MECKLENBURG COUNTY
Park and Recreation Department

MEMORANDUM

RE: Rezoning Petition #2022-078
PID# 06905104

SHEET NUMBER RZ-01

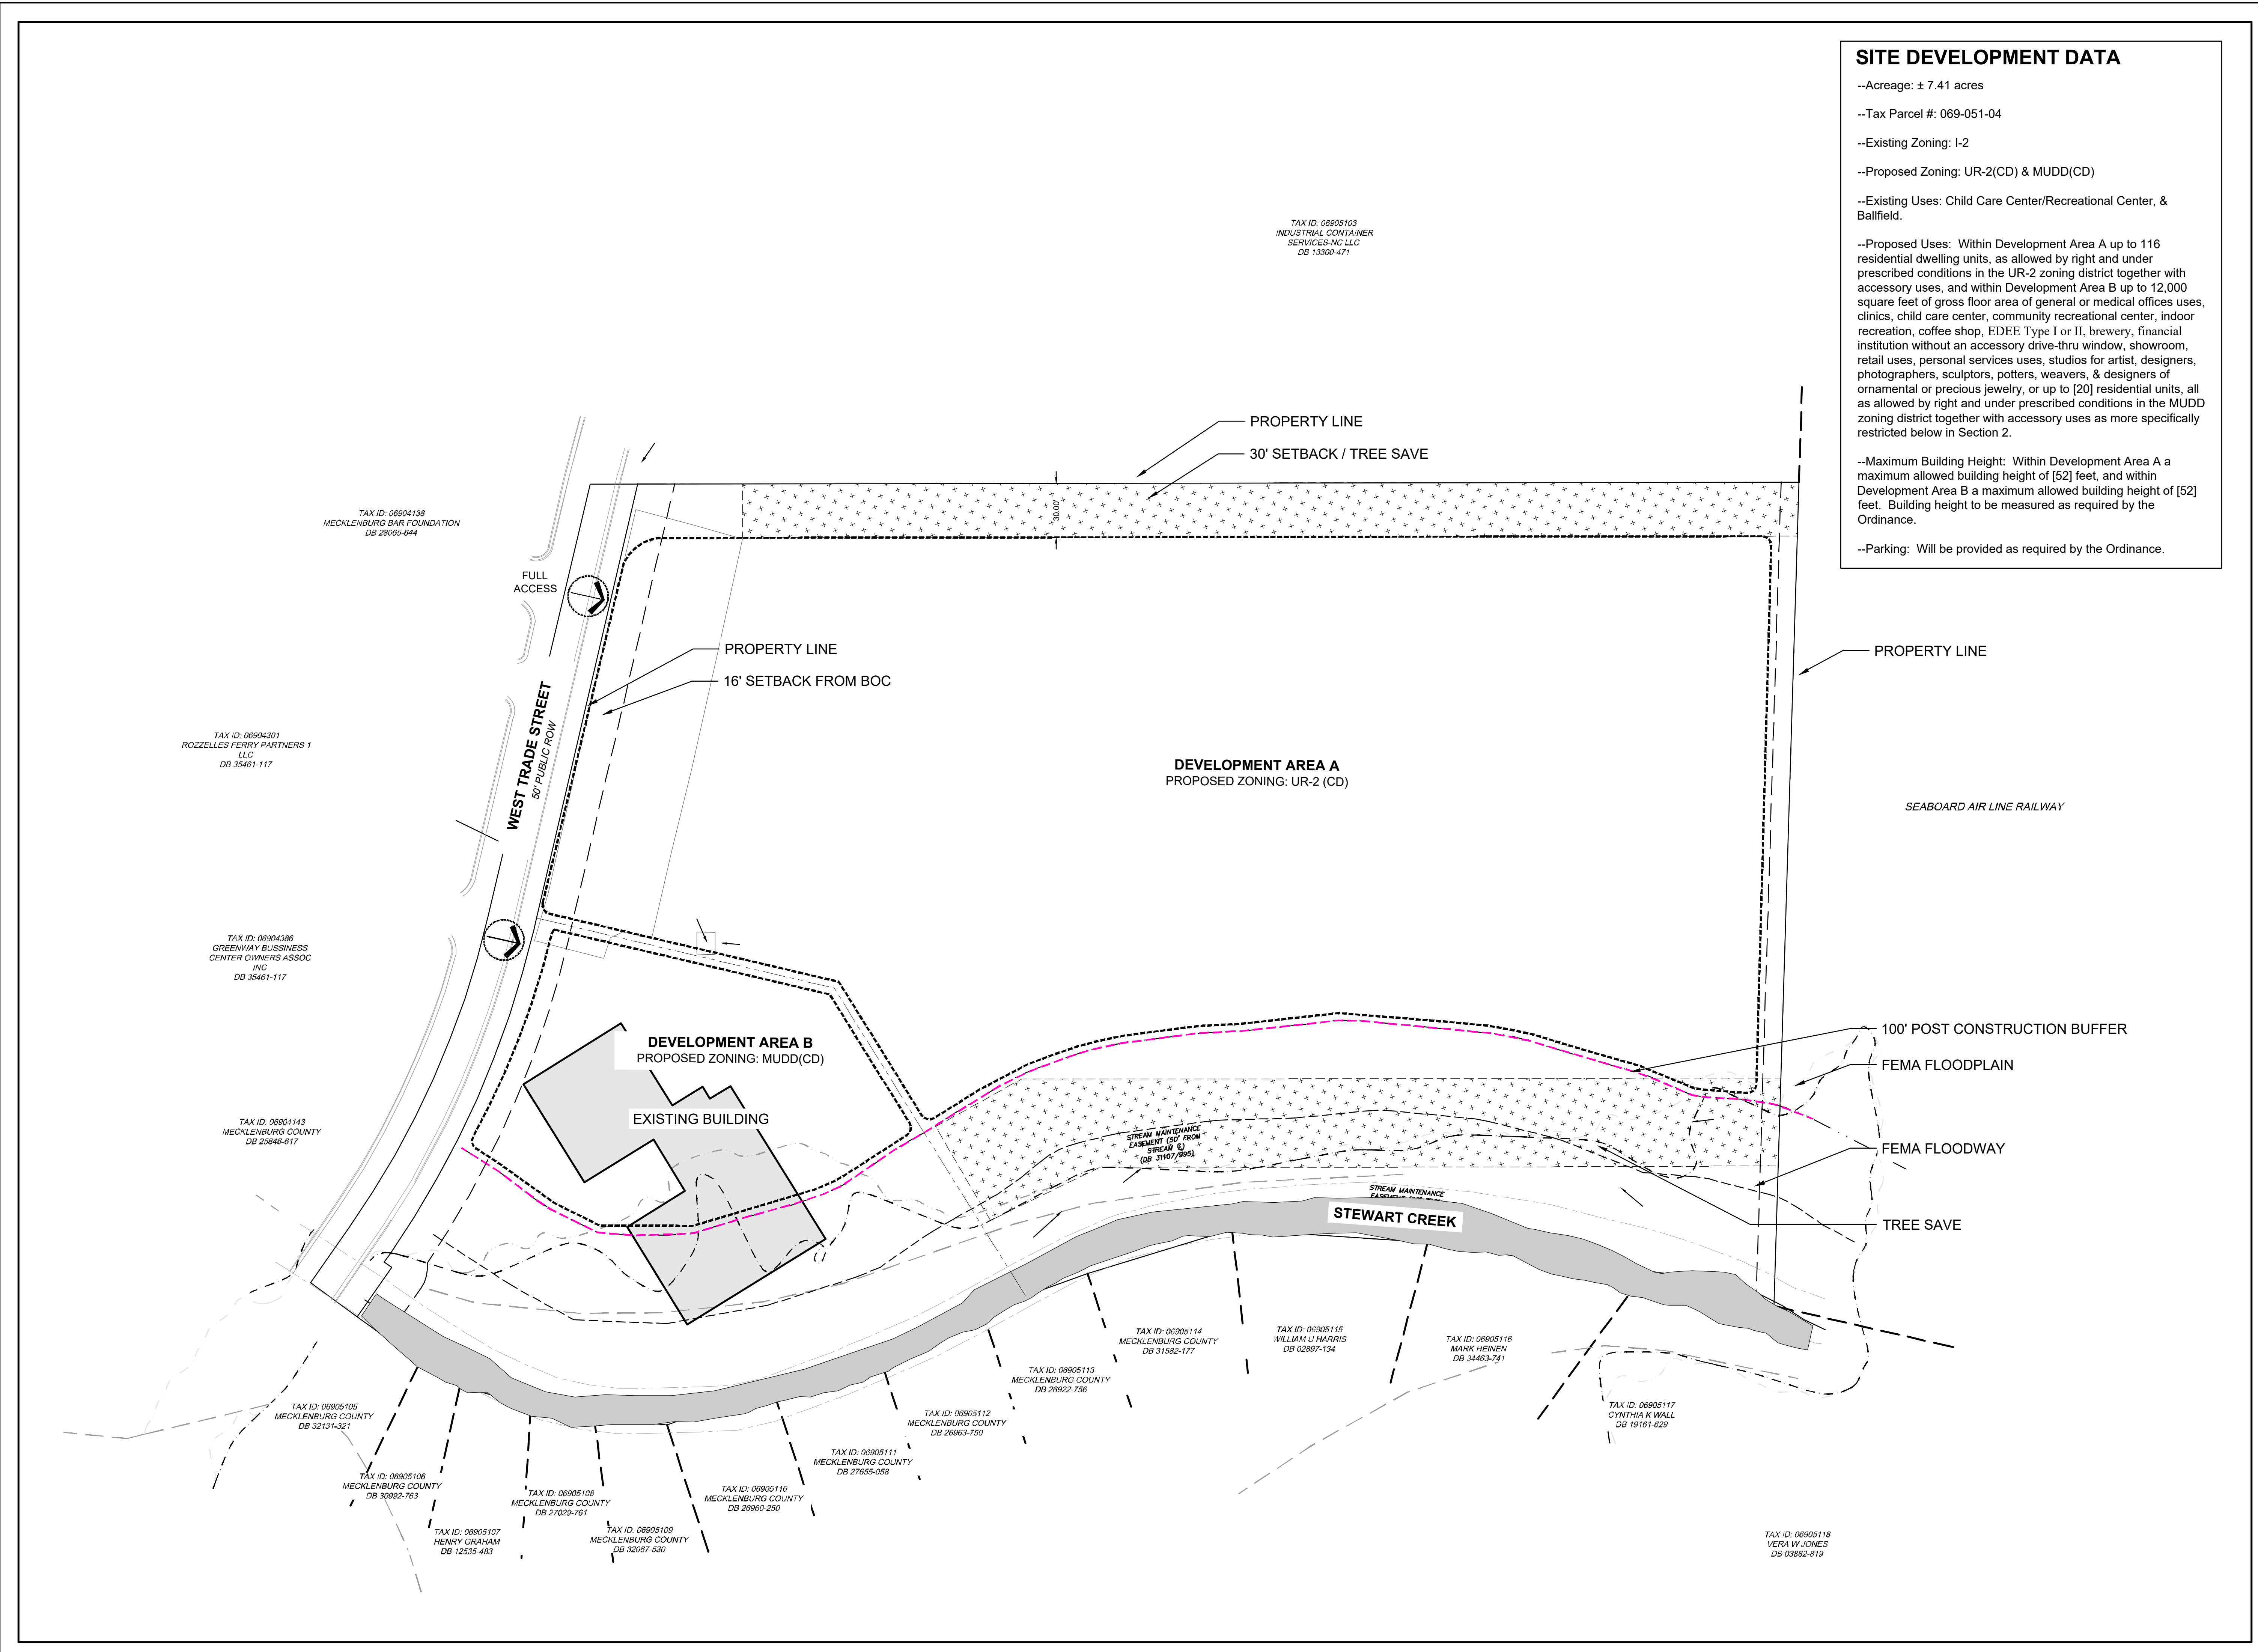
This parcel is on the MCPR Greenway Master Plan. MCPR requests the petitioner dedicate and convey or provide a greenway and storm water easement to Mecklenburg County which would include a minimum of the 100' SWIM Buffer of Stewart Creek for future greenway trail. The easement area should exclude built structures. If the existing structure remains, MCPR requests an alternative bicycle/pedestrian connection between the dedicated SWIM buffer area and the W. Trade Street public ROW. In addition, MCPR requests a minimum of 60' easement between the greenway trail dedication area and the development ROW to provide an access for residents of the development.
